RE: Sub 19-002

Address: 2825 W Mercer Way
Development of Old Boys/Girls
Club into 14 single family homes

PRELIMINARY TREE RETENTION AND REPLACEMENT PLAN
2825 W MERCER WAY
PRELIMINARY PLAT
 PARCEL #2174502425
 CITY OF MERCER ISLAND WASHINGTON

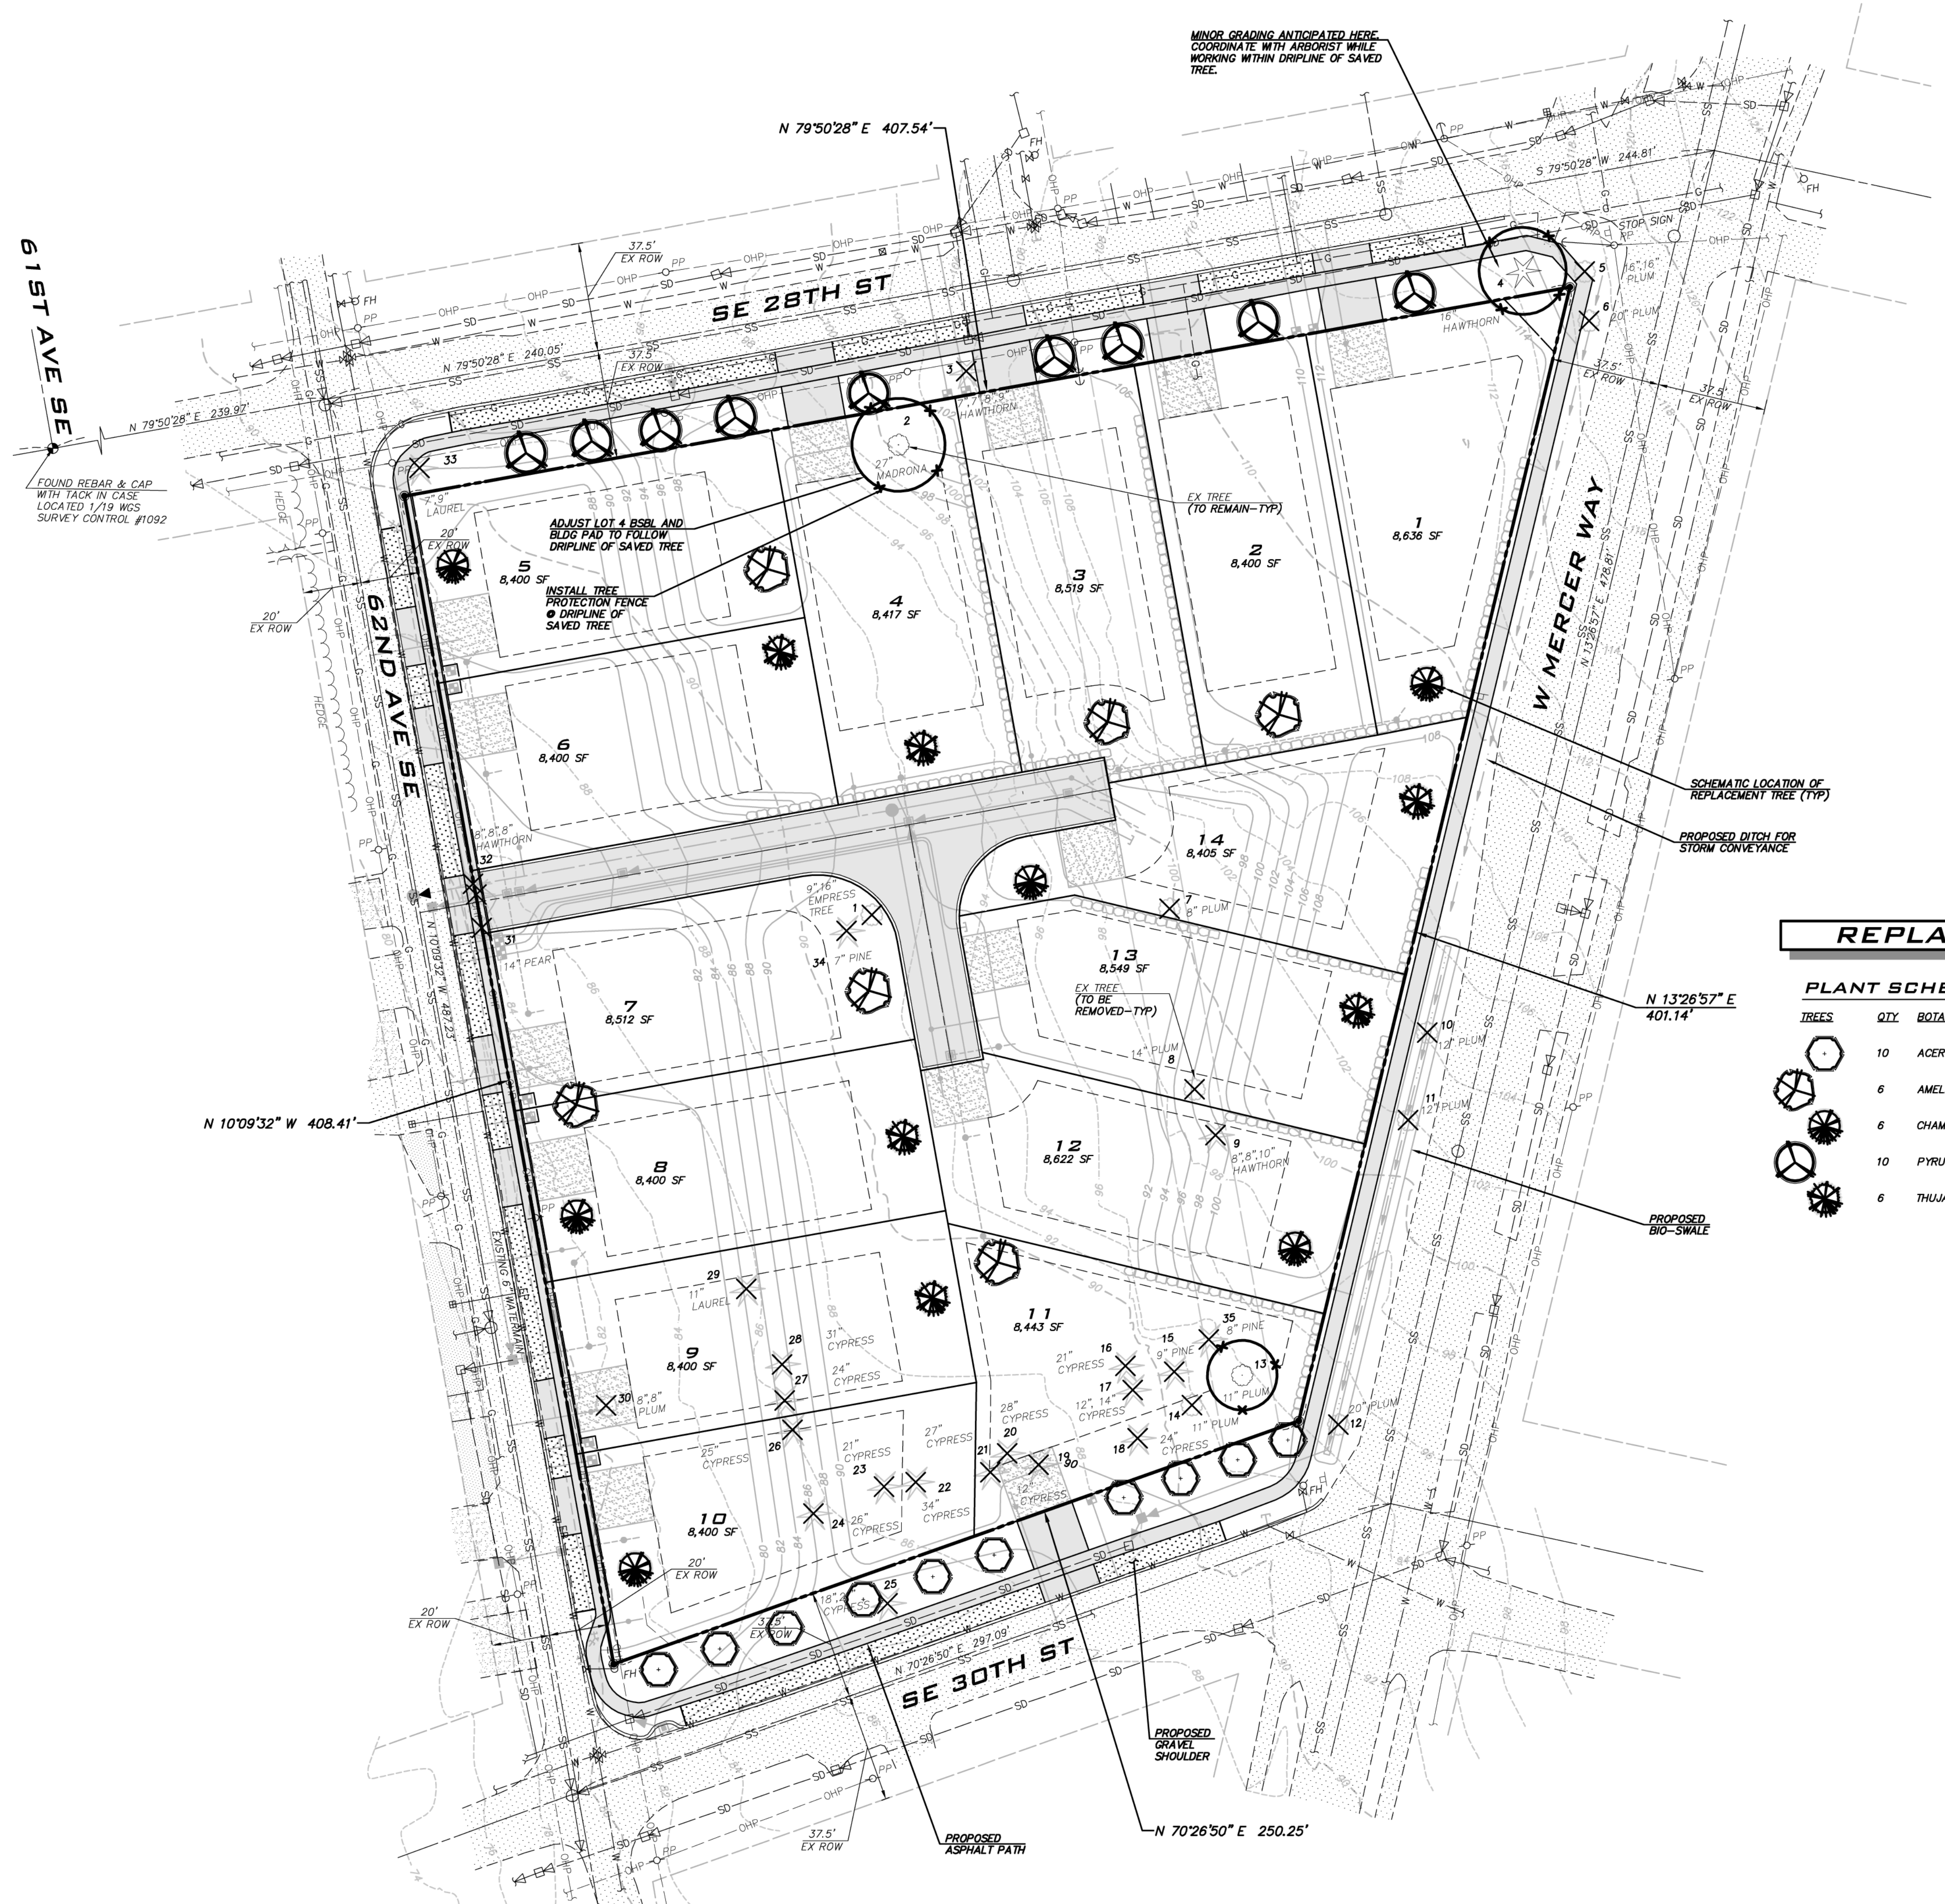
Point 1: Tree #2 exceptional
Madrone tree. This tree must be
saved at all costs. It is one of
the last Madrones left in the East
Seattle neighborhood. It is healthy
and flourishing. Unfortunately, it
is located on the edge of the
hill (bank) that will surely
be graded out. Madrones
tend to die if the roots are
disturbed. According to the plans
of Lot #4 it will be located
next to the driveway and
house. This is fantasy! It will
never survive. The new home
owners will tire of the constant
fall of the crackerly leaves.

Therefore, I ask the city of Mercer Island to deny the building of a home on Lot # 4 in order to save this tree.

Point 2: Tree #25 Leland Cypress. This healthy tree should be saved! Surely the builders can route the drainage line around the root ball. The property owners are the ones who planted the Leland Cypress's. Surely, they knew how fast they would grow. This tree could be the East Seattle Xmas tree. I ask the city of Mercer Island to save this tree.
